## Stonestreet Solar

This paper covers how the Evolution Power application does not address LPA planning policies and guidance. It identifies reasons for refusal that I would present to a planning committee were ABC the planning authority.

### Framing System - Front & Side Elevations - 1:100@A3

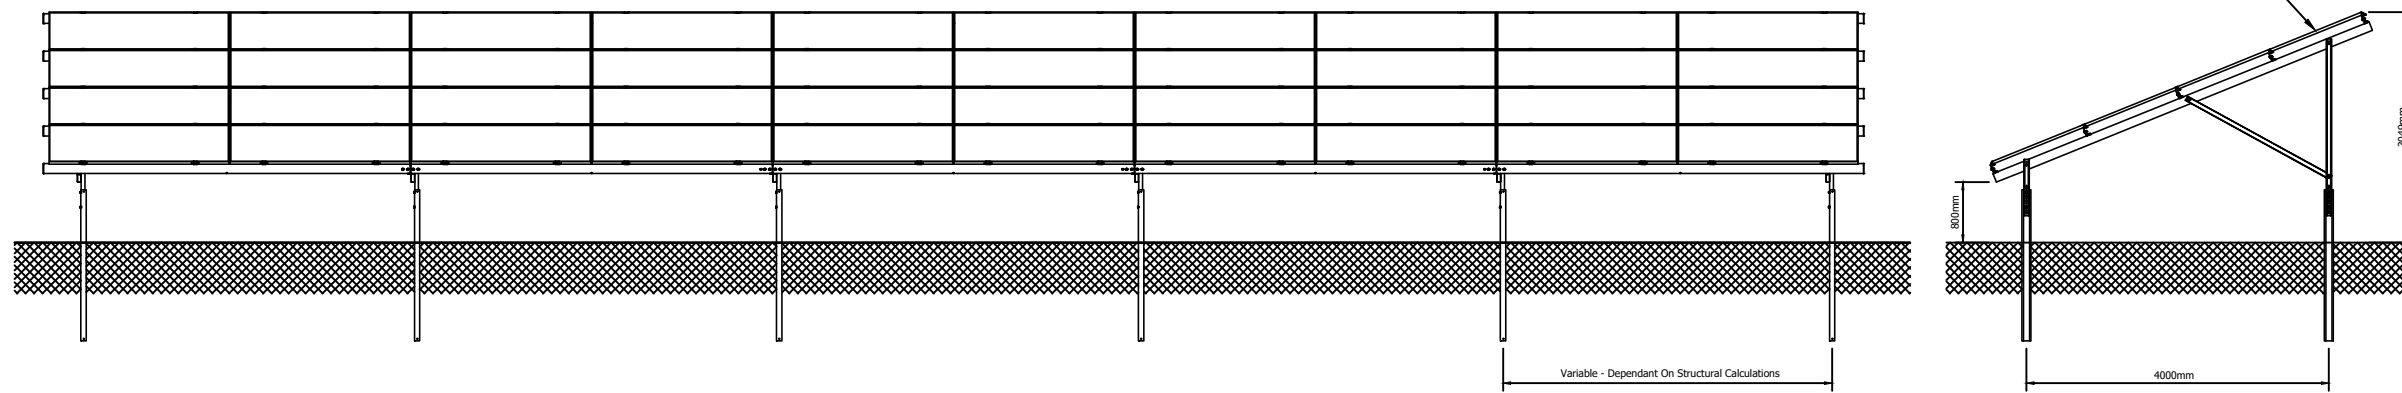
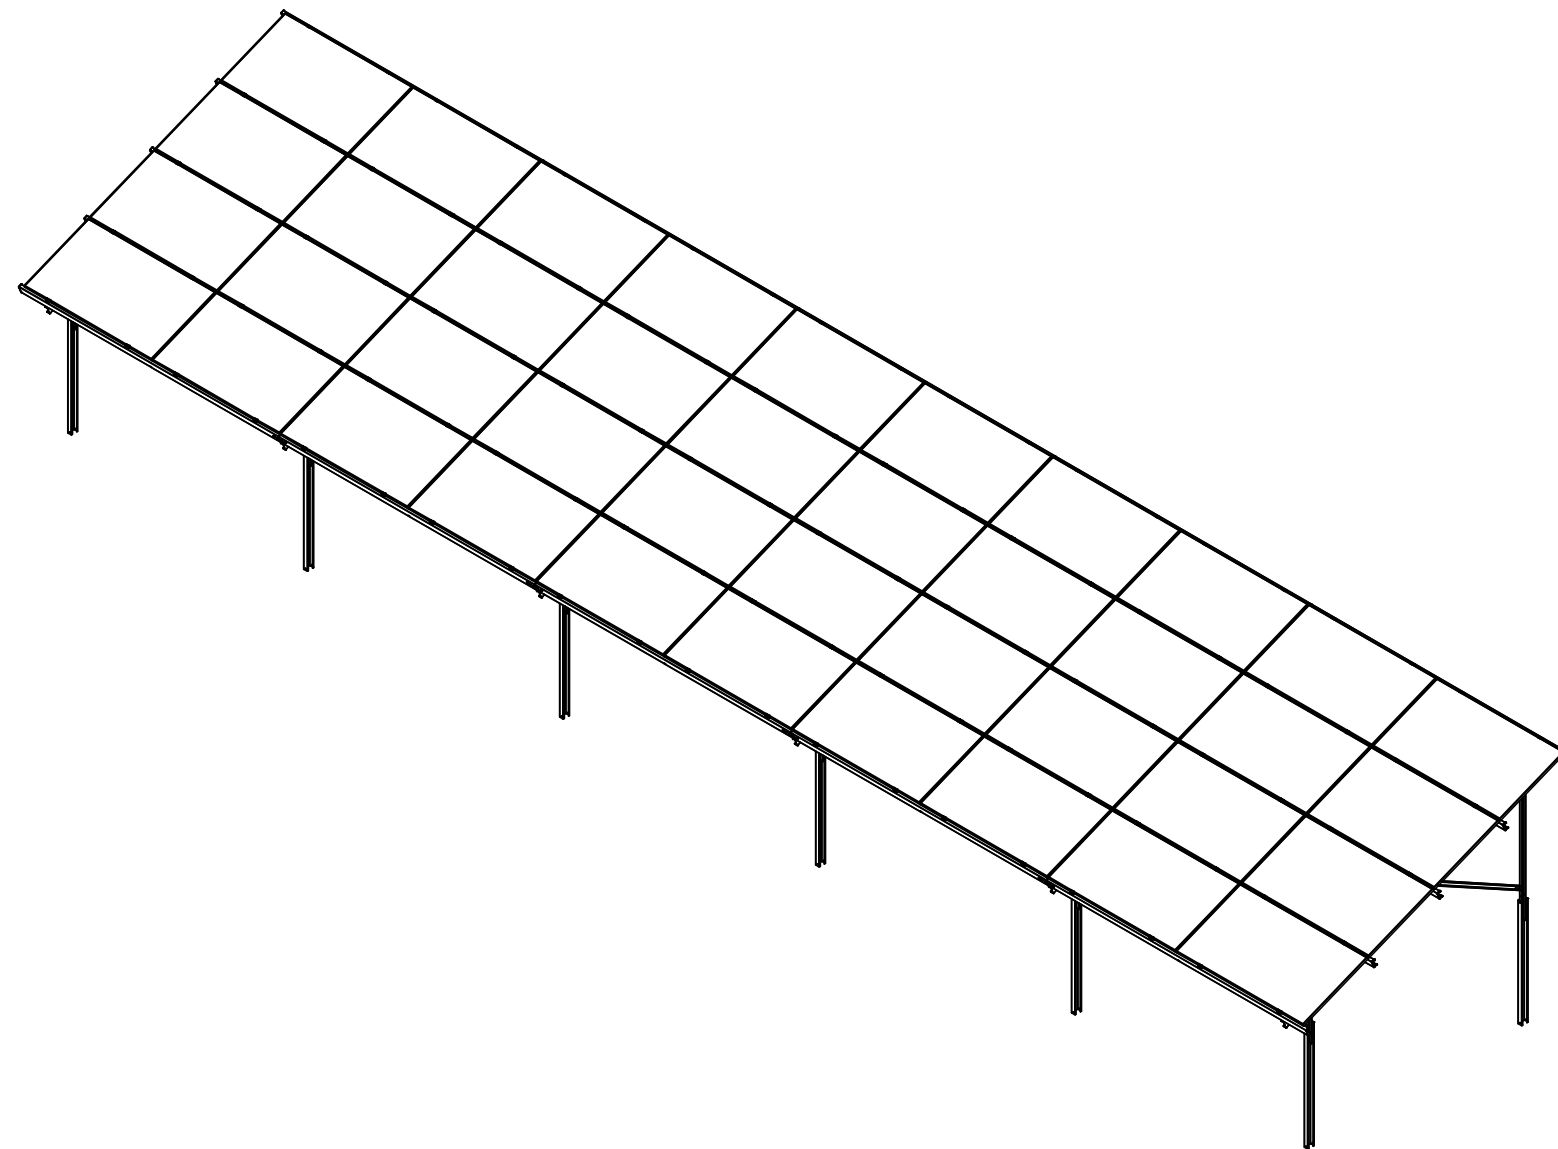
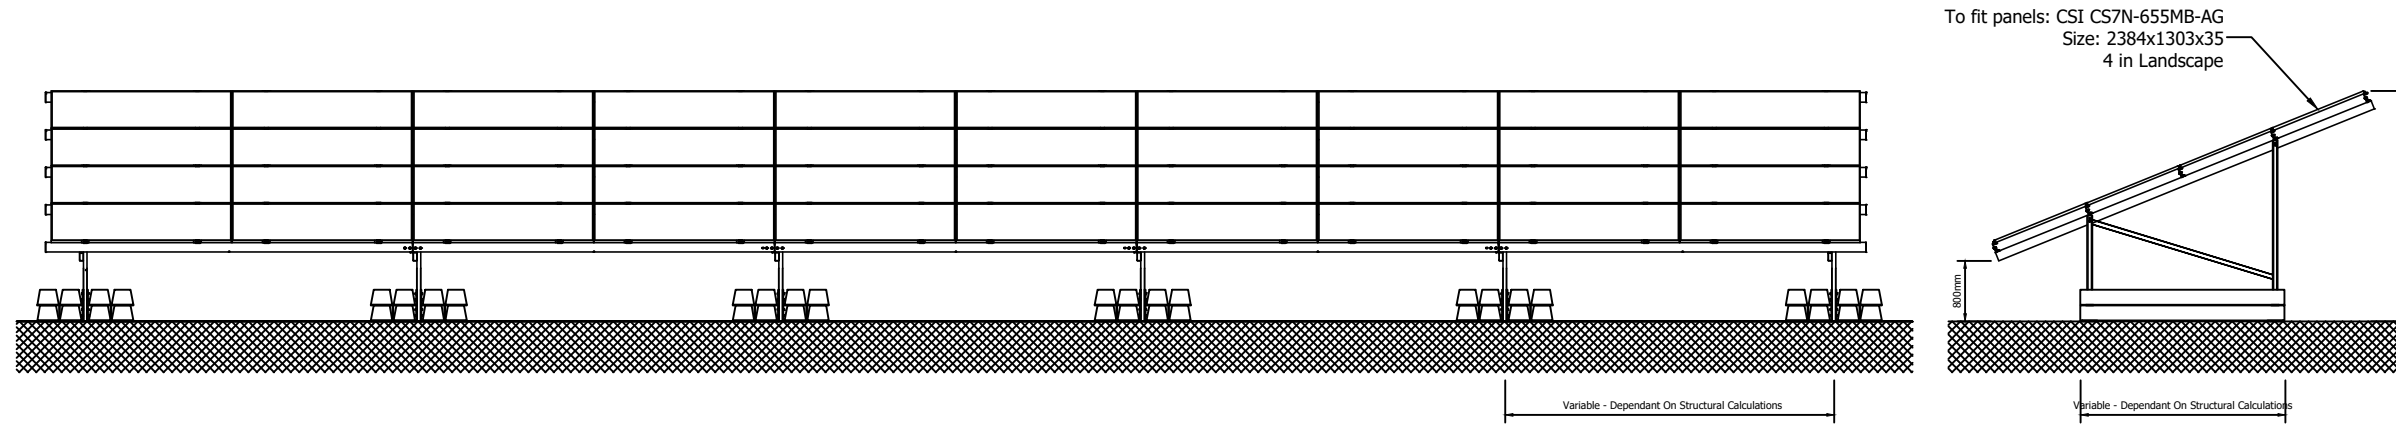
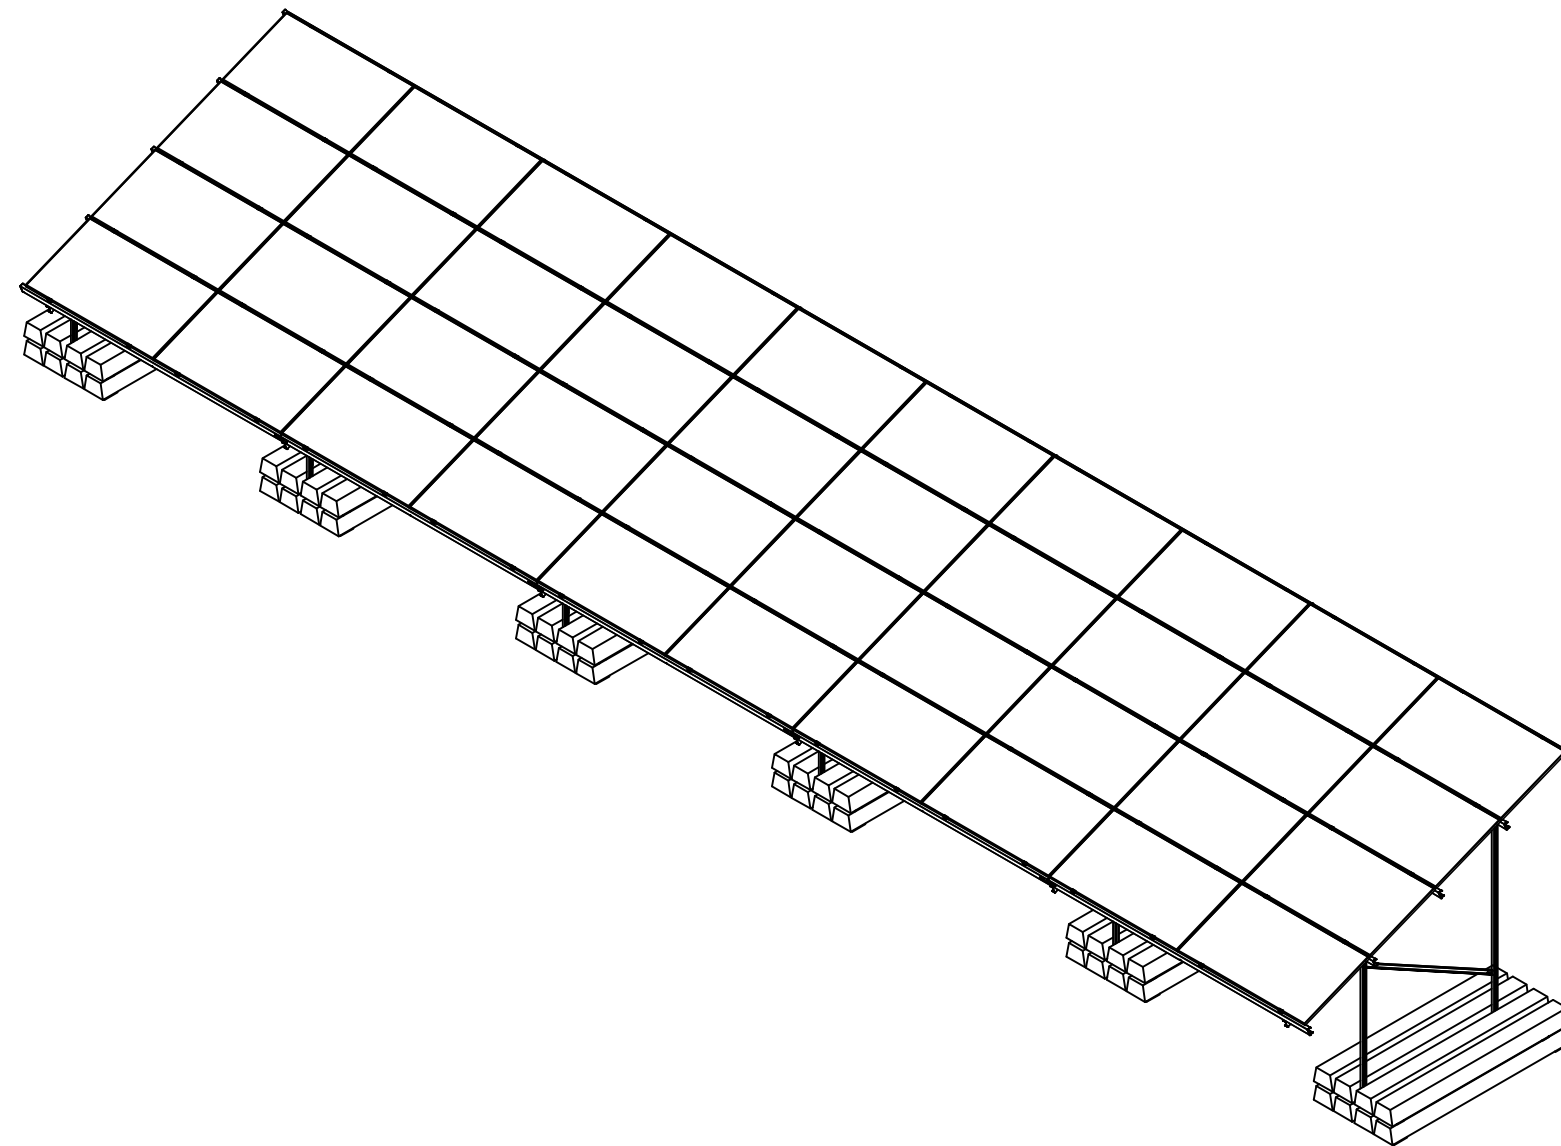
The PV panels are 0.8m above the ground and it is proposed that this would allow grass to grow and sheep to graze and so agricultural use will continue. The average height of a sheep is 120cm so I wonder if this statement by the applicant is correct, grass growth would not be sufficient to maintain livestock throughout the year and for that reason there will be an adverse impact on soil quality.

**ABC guidance requires the height to be 900mm above ground level. This condition is not met and so is a reason for refusal.** Were this application to be approved, I would ask for a planning obligation that 95% of the land **will remain** in agricultural use is required (not just "**available for**" agricultural use). An annual report should be prepared by the applicant confirming stocking rates month by month.
